## Chair of Frodsham Town Council's response to Solar farm application.

This is a personal response from Helen Hayes, Chair of Frodsham Town Council. The Council will be officially responding to the Solar Farm application via the Frodsham Neighbourhood Plan group.

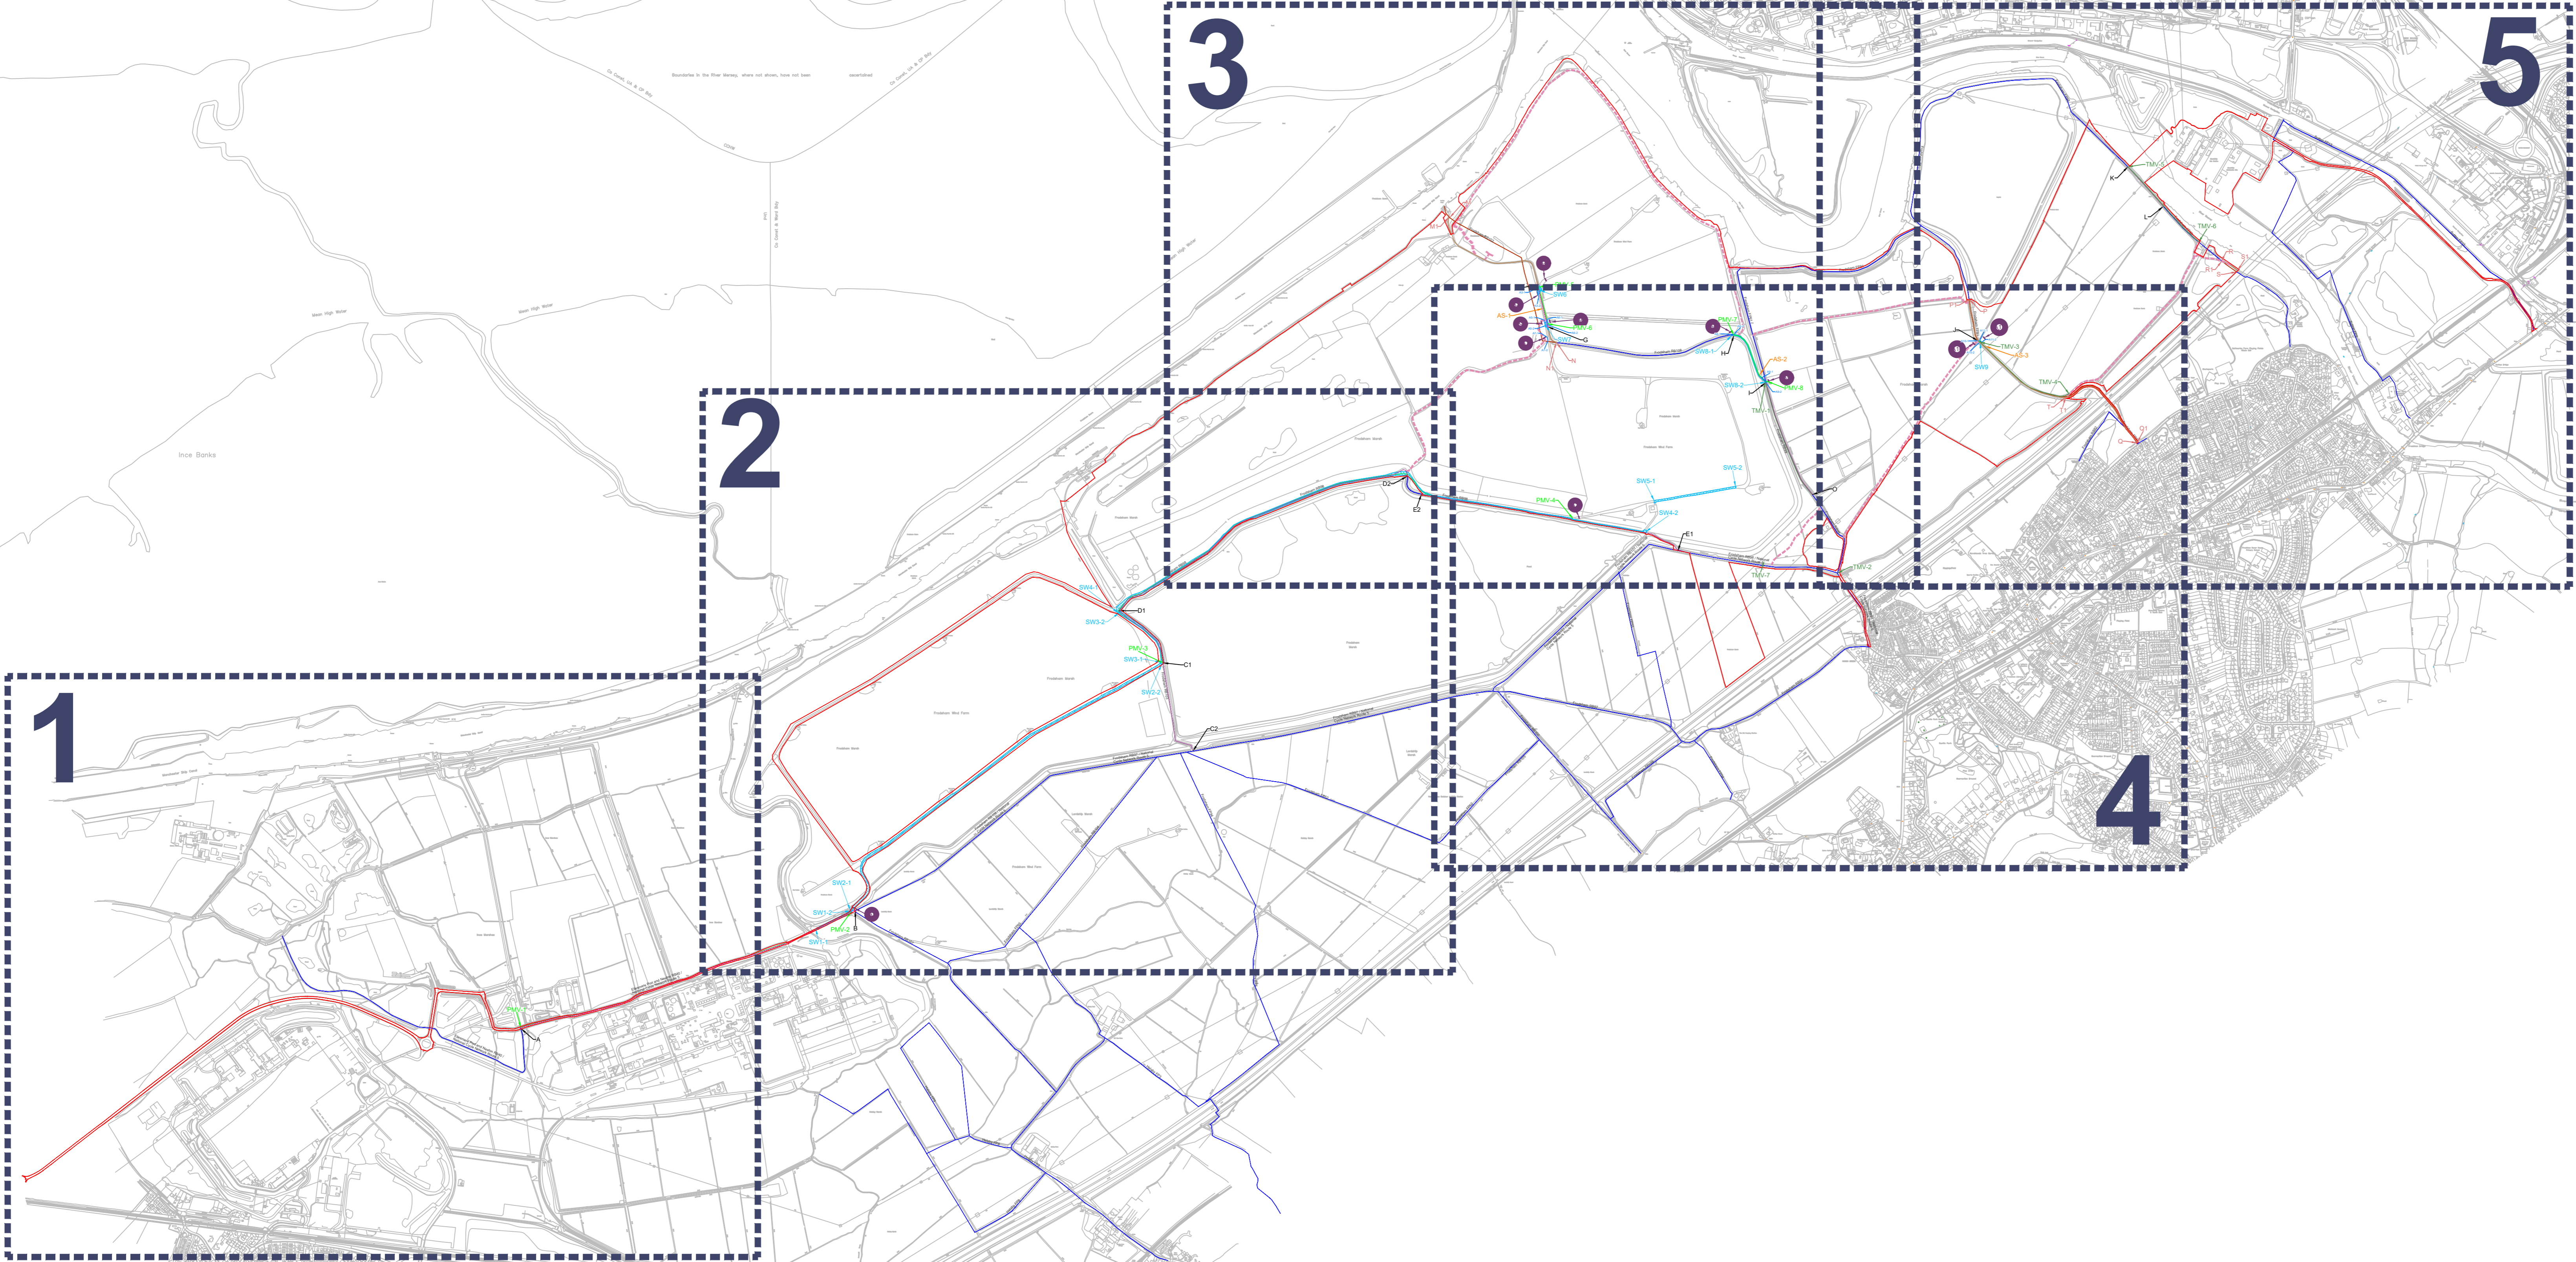
The 4.5km of planned new tracks are potentially very welcome. However, it is very difficult for residents to visualise what it would be like to use them from the limited number of photo predictions provided and the applicant ignored a request (FS2\_EF\_006) in its' responses to create either a scale model or a 3D virtual tour.

It is important that the applicant includes a wide variety of perennial shrubs & bushes alongside each track to break the monotony of what could otherwise be very monotonous corridors of steel work.

Currently many sections of these Byways which link the site to the town are very badly degraded due to frequent use by heavy agricultural vehicles and are worse in winter with deep flooded potholes. Note: photographic evidence is available. This has a serious adverse impact for not only leisure, commuters and service vehicles but potentially for access by emergency services. We believe that these byways should be improved as part of the scheme and that two national and Cheshire West policies are applicable. i.e.
